DECISION DELEGATED TO HEAD OF PLANNING

Application No: H08-0417-24 **Applicant:** RTW Construction & Development

Proposal: Details of precautions to be taken to prevent mud deposits on public highway etc, scheme for on-site foul water drainage works, existing & proposed site levels & proposed floor levels, construction management plan & method statement, finished surface levels for estate roads & footways, estate road phasing & completion plan, surface water drainage scheme, additional boundary treatment for northern boundary of Plot 1, plan to illustrate all areas of publicly accessible open space, details of management and maintenance schedule for areas of landscaping, incidental open space, refuse/recycling collection points & parking courts/private drives, management & maintenance including refuse/recycling collection points for Plots 12-14 and design & position of all external meter boxes & gas flues & soil vent pipes (Conditions 3, 4, 5, 7, 9, 10, 11, 13, 14, 15, 16 & 17 of H08-0870-22)

Location: Site Adj. Silverdene Boston Road Gosberton

DRAWING			Boundary Treatment Plan		
DRAWN		PROJECT DESIGNER		PROJECT DIRECTOR	
EG		KB		KB	
DATE		SCALE		PAPER SIZE	
10.11.2021		1:500		A1	
DRAWING NUMBER					
525.BT.01					
Working in partnership with Ralph Charman Associates & Eleven Consultants

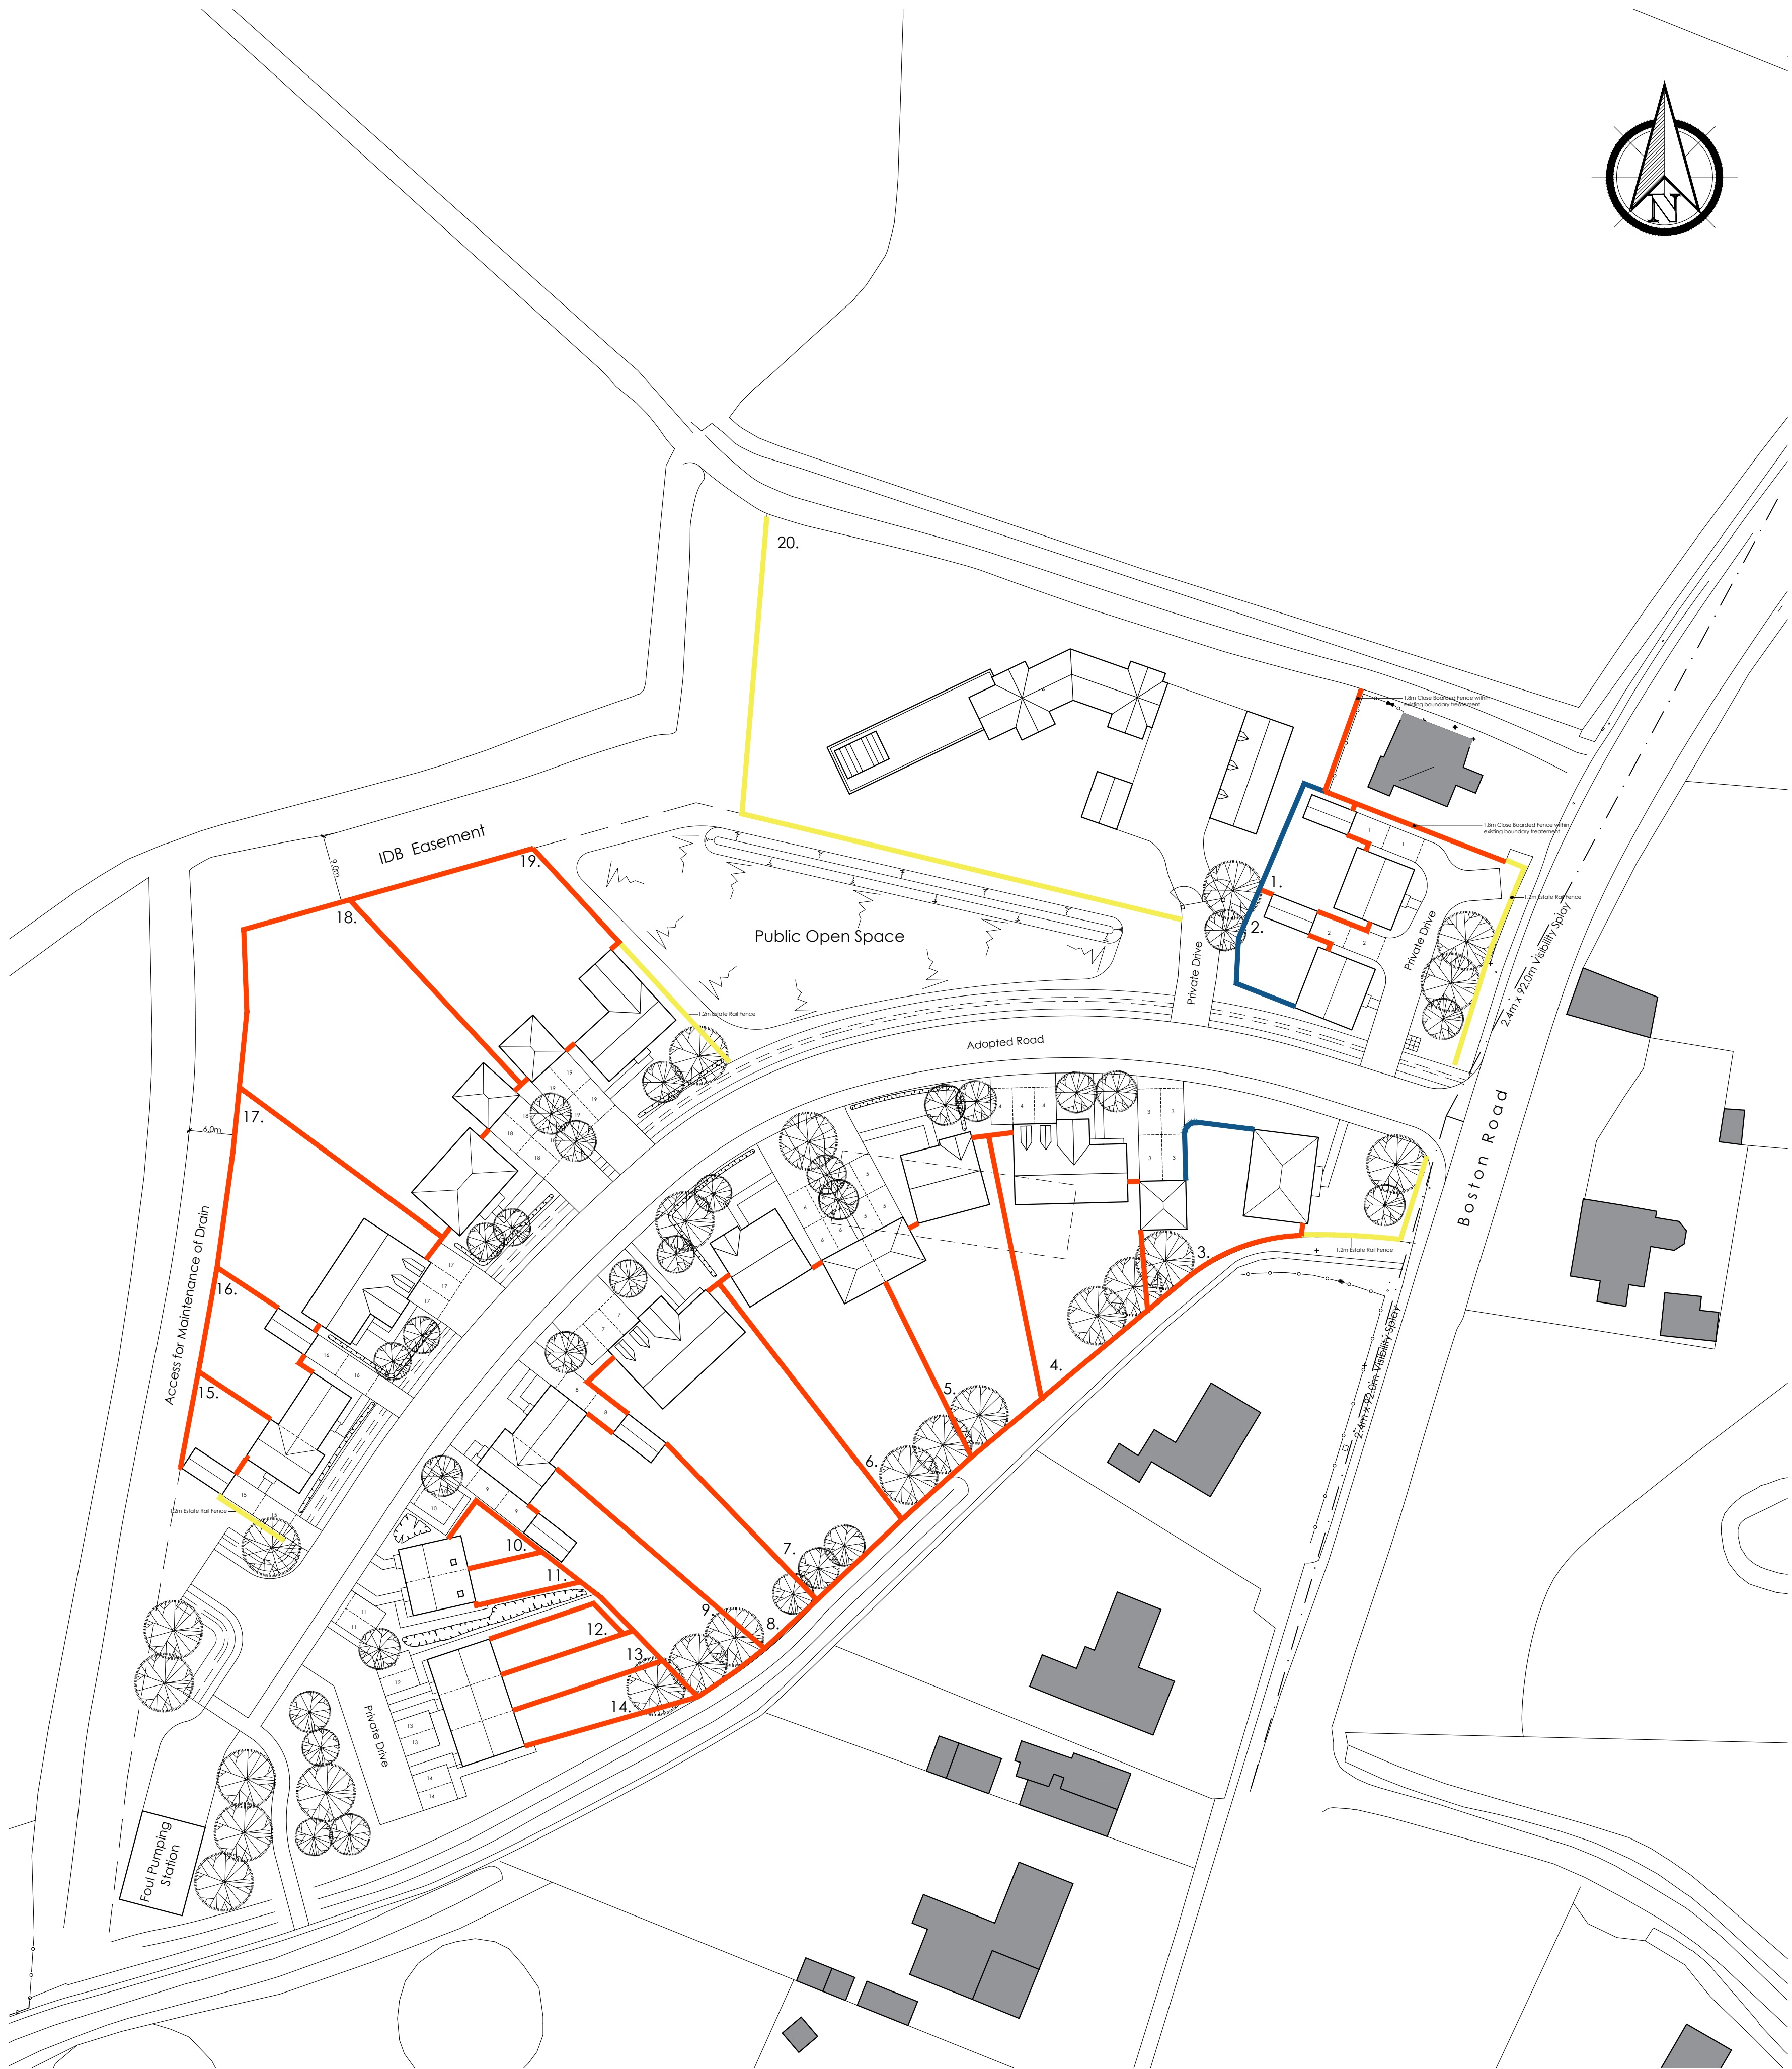
Insufficient information has been provided in relation to Condition 13. The details relating to the northern boundary treatments appear to be relatively standard. However, the full assessment of their acceptability is not possible, due to the full details of land levels not being provided. The information for this condition, therefore, is insufficient and Condition 13 is unable to be discharged.

CLIENT	RTW Construction & Developments Ltd	
PROJECT	Proposed Residential Development on land off Boston Road, Gosberton	
DRAWING	Maintenance Responsibilities Plan	
DRAWN	PROJECT DESIGNER	PROJECT DIRECTOR
EG	KB	KB
DATE	SCALE	PAPER SIZE
16.12.2022	1:500	A1
DRAWING NUMBER	525.MRP.01

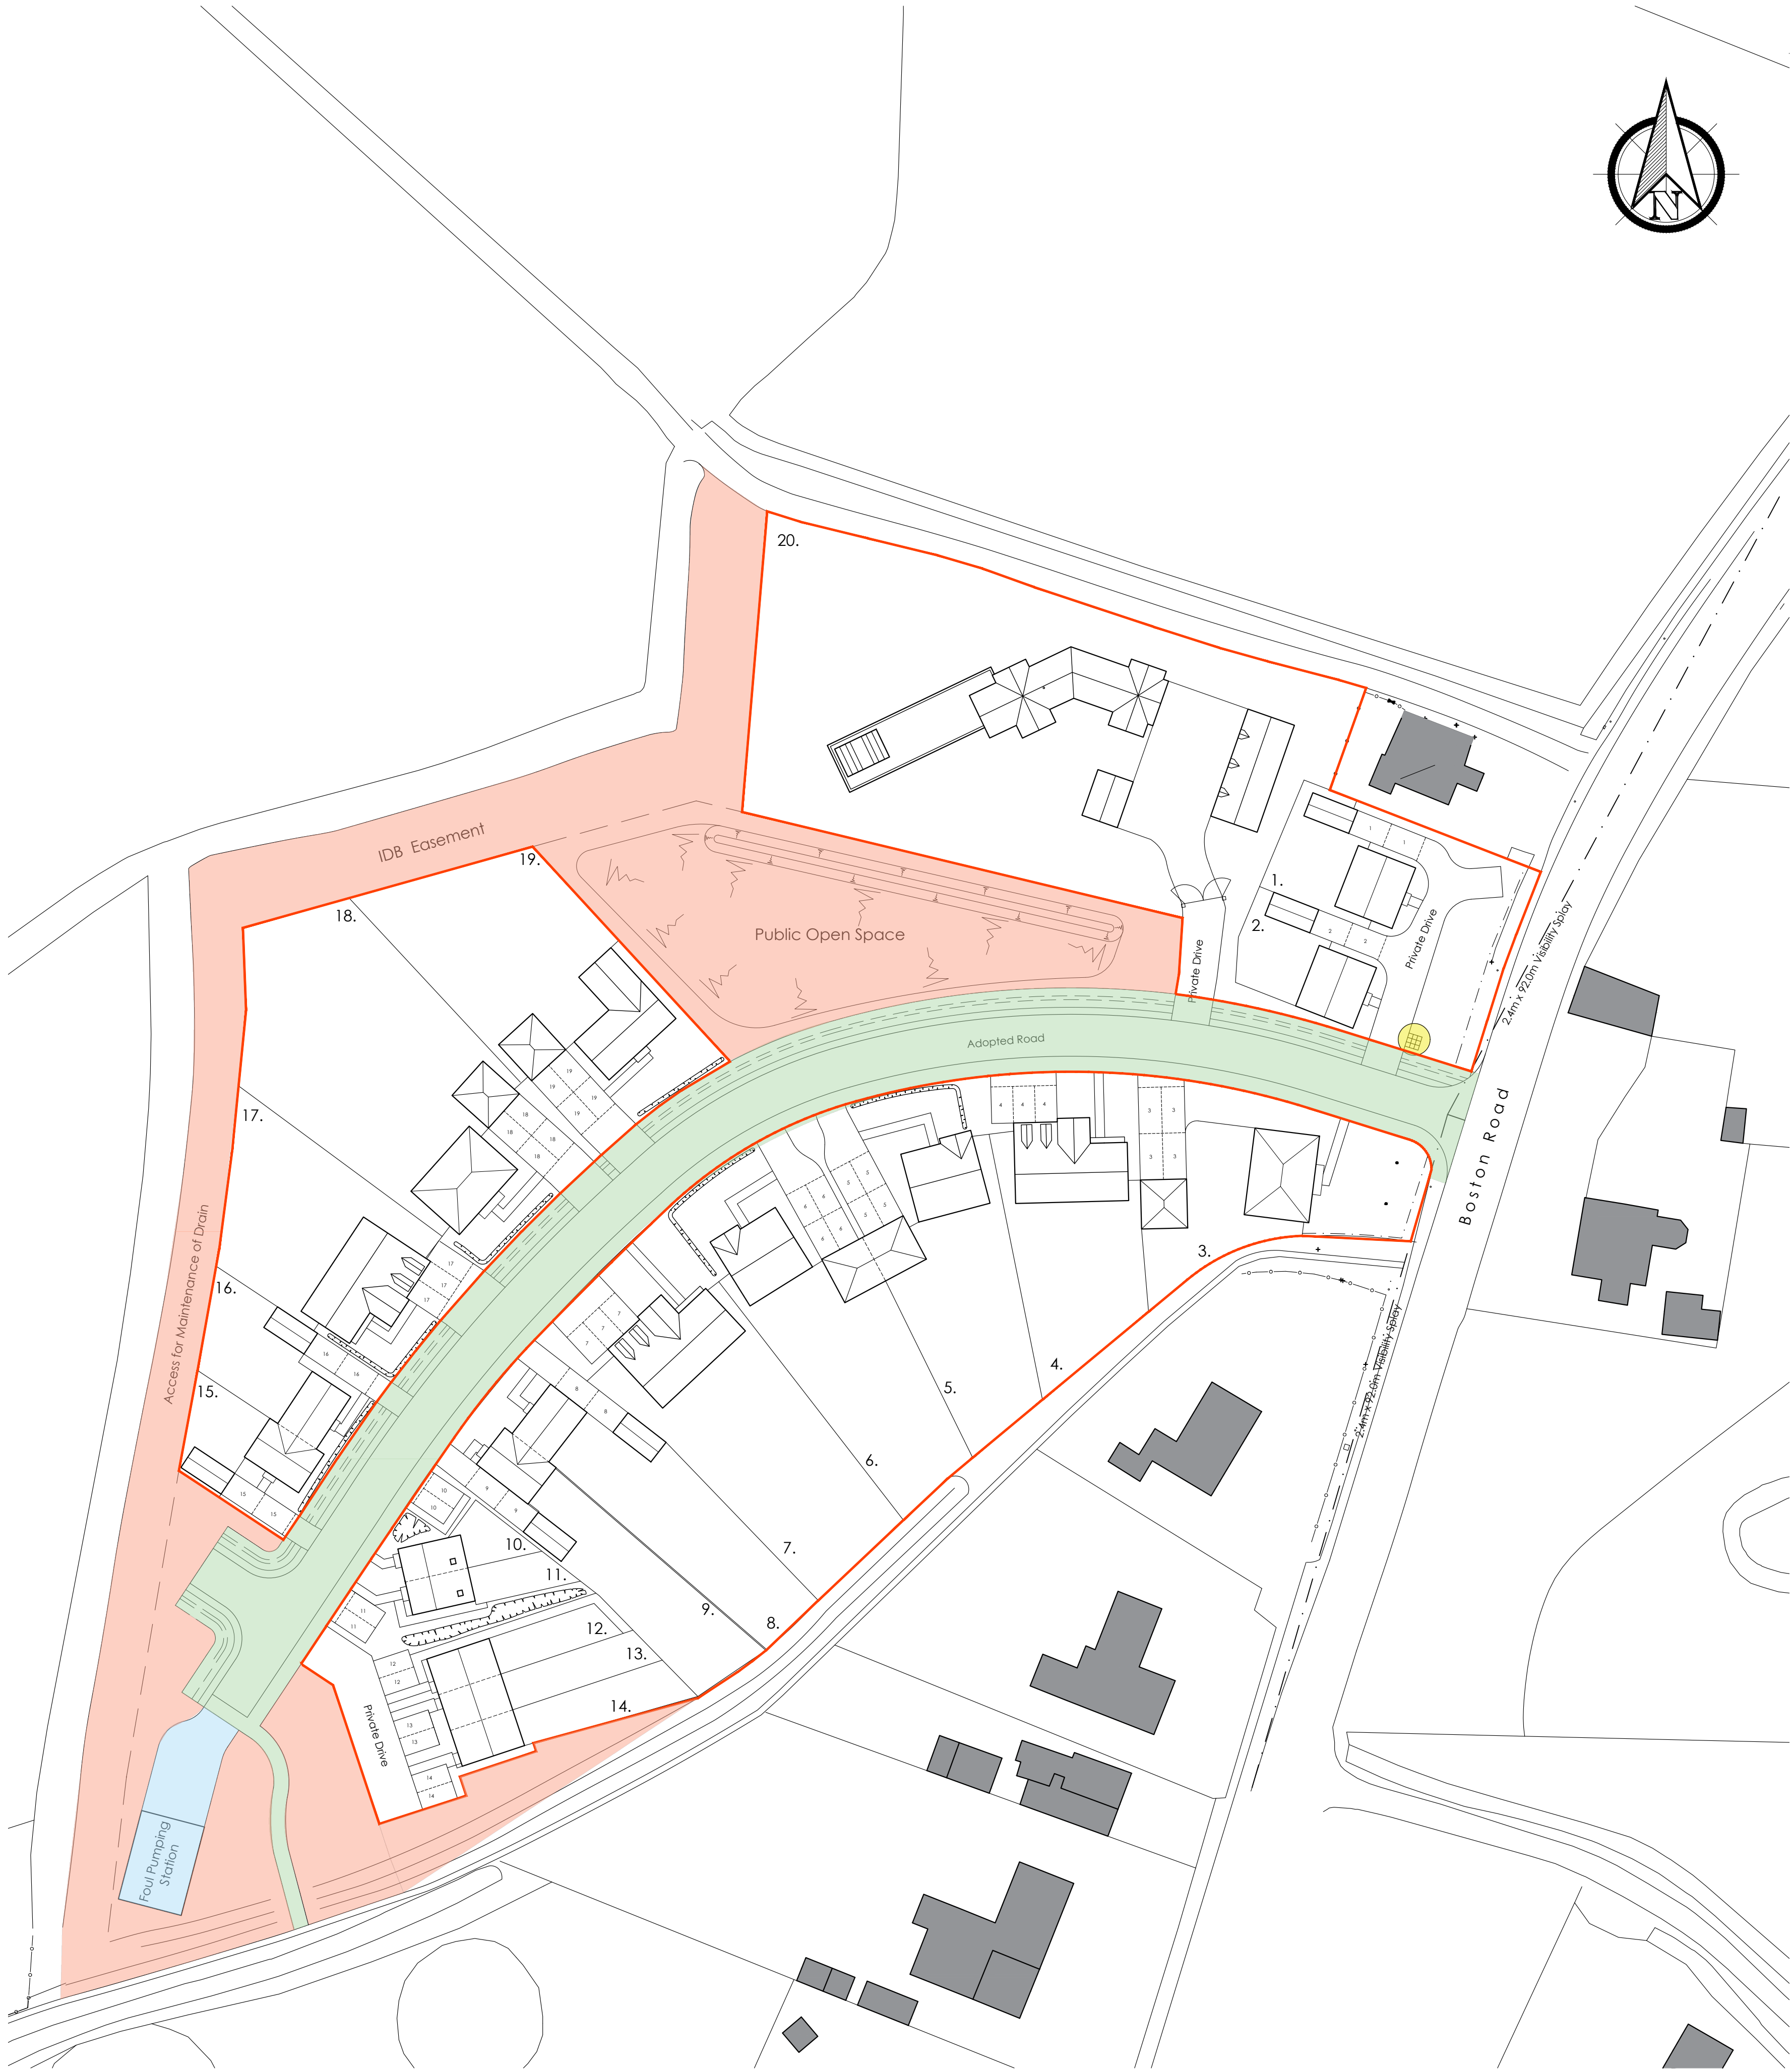
Insufficient information has been provided in relation to Condition 14. Although the submitted maintenance plan suggests the areas of open space, no specific details appear to have been submitted that clearly identify these areas. Moreso, the submission does not detail the specification of these areas (i.e. no details of the basin, or how this can be provided as an accessible open space, have been submitted). Furthermore, no details of timing or phasing of these spaces have been submitted. The information for this condition, therefore, is insufficient and Condition 14 is unable to be discharged.

Insufficient information has been provided in relation to Condition 15. The submitted information, illustrates the management responsibilities for all areas of the site. However, given that the details relating to open etc, as outlined within condition 14 above, have not been provided, it is not possible to assess the acceptability of their maintenance and management.
